From: Contact Centre (CRM) <contact@ribblevalley.gov.uk>
Sent: 30 December 2022 11:38
To: Planning
Subject: Planning Application Comments - 3/2022/1038 FS-Case-474839288

Planning Application Reference No.: 3/2022/1038

Address of Development: Corner Moorgate Lane, Kenyon Lane,
Dinckley BB6 8AN

Proposed Site Plan - 1:200

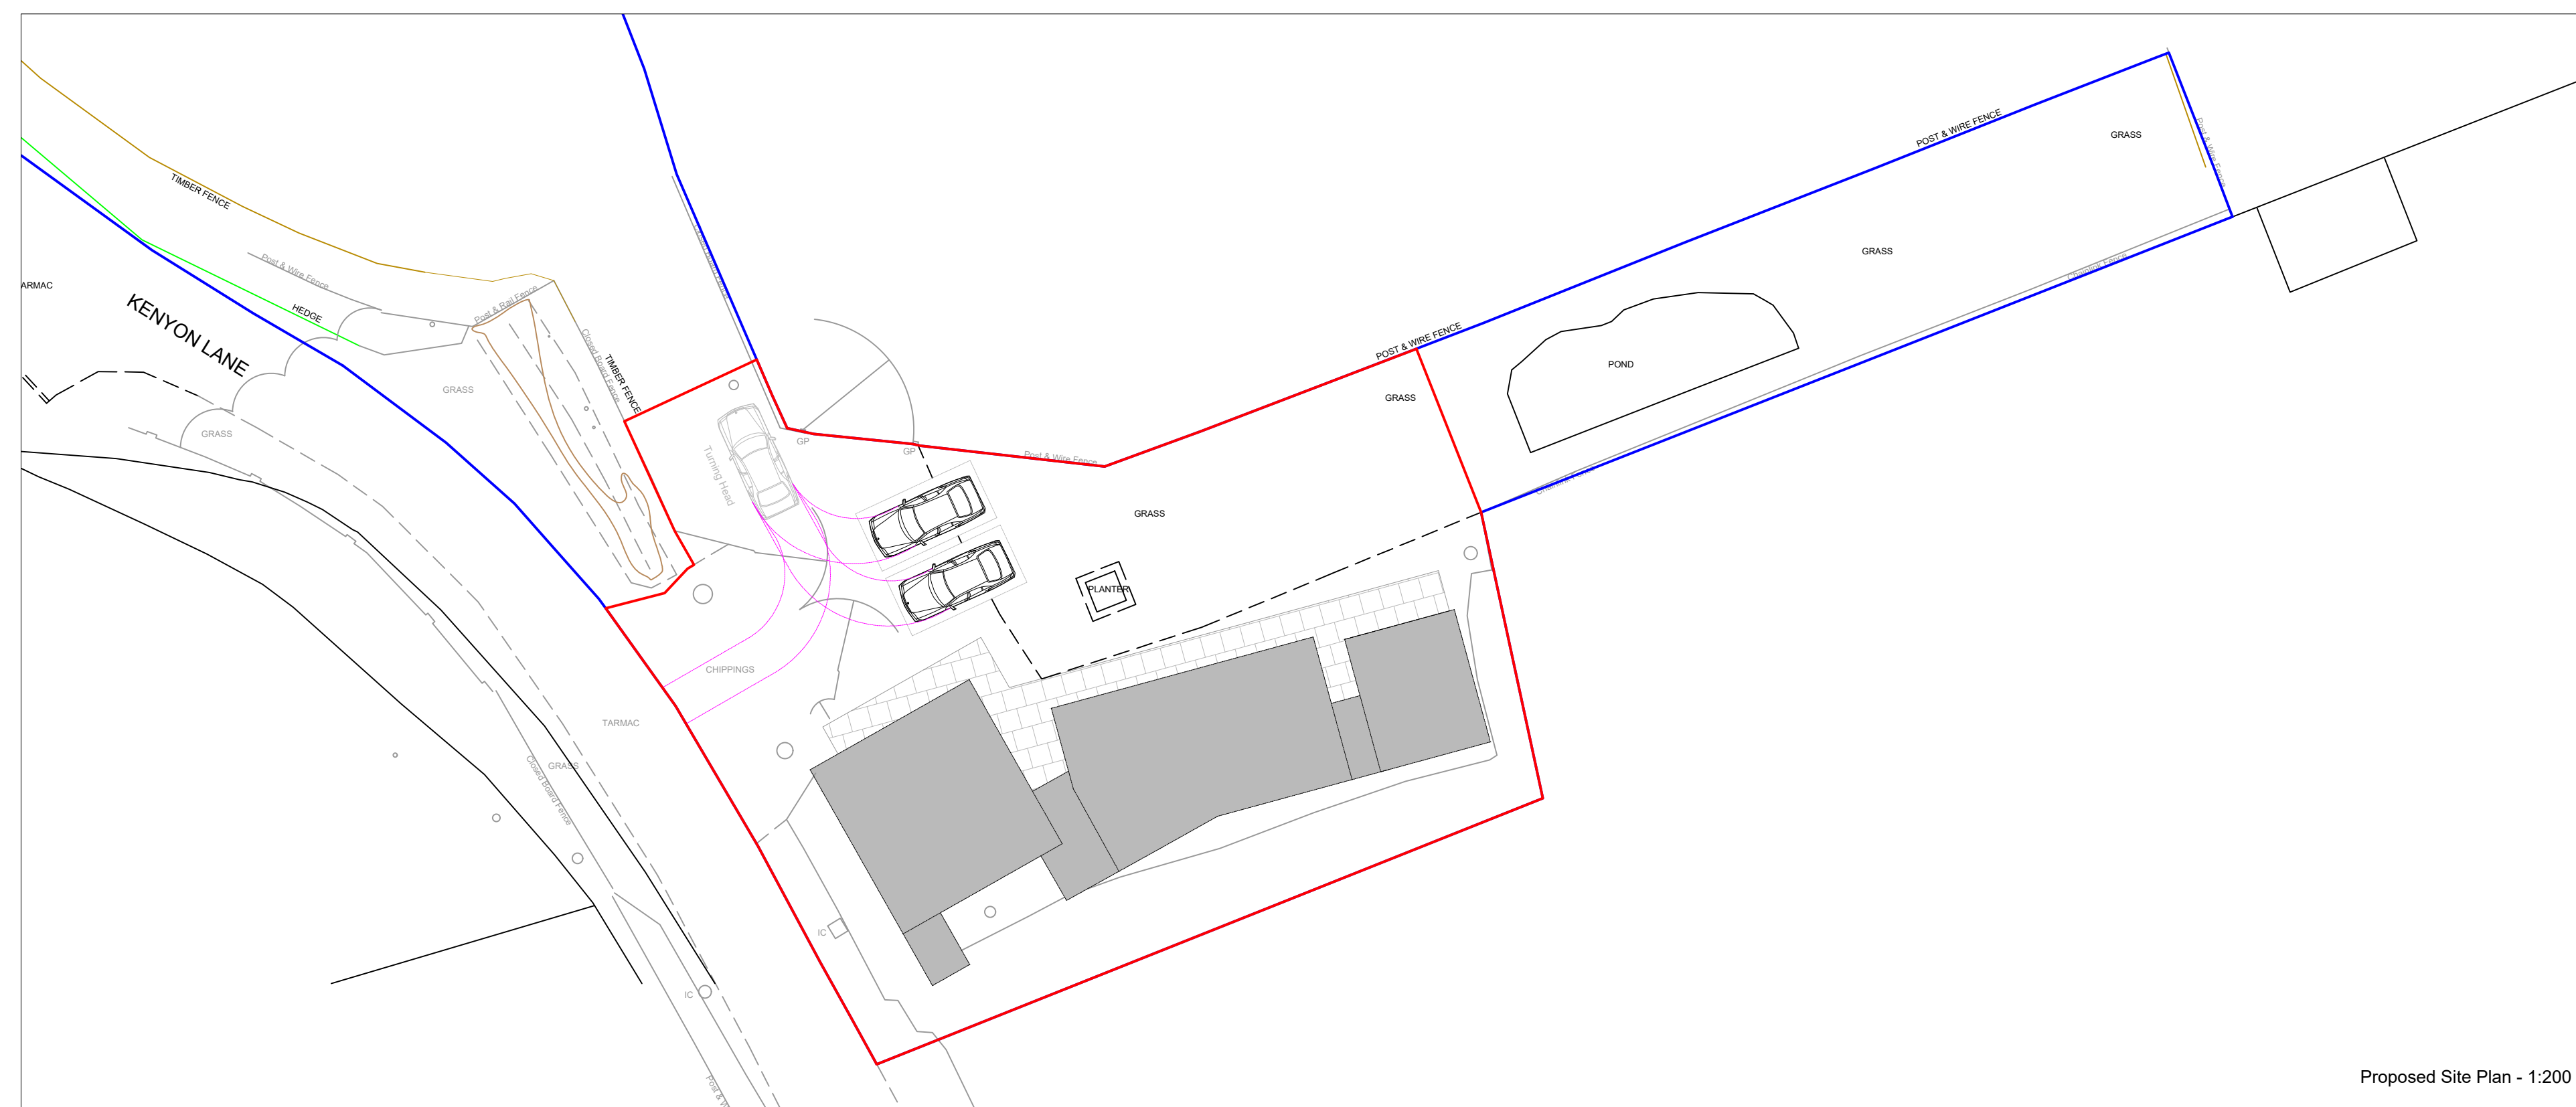
On the proposed site plan where the 2 vehicles are parked there is a gate into Moorgate Farm and [REDACTED] Moorgate Farm land for agricultural purposes through this existing gateway.
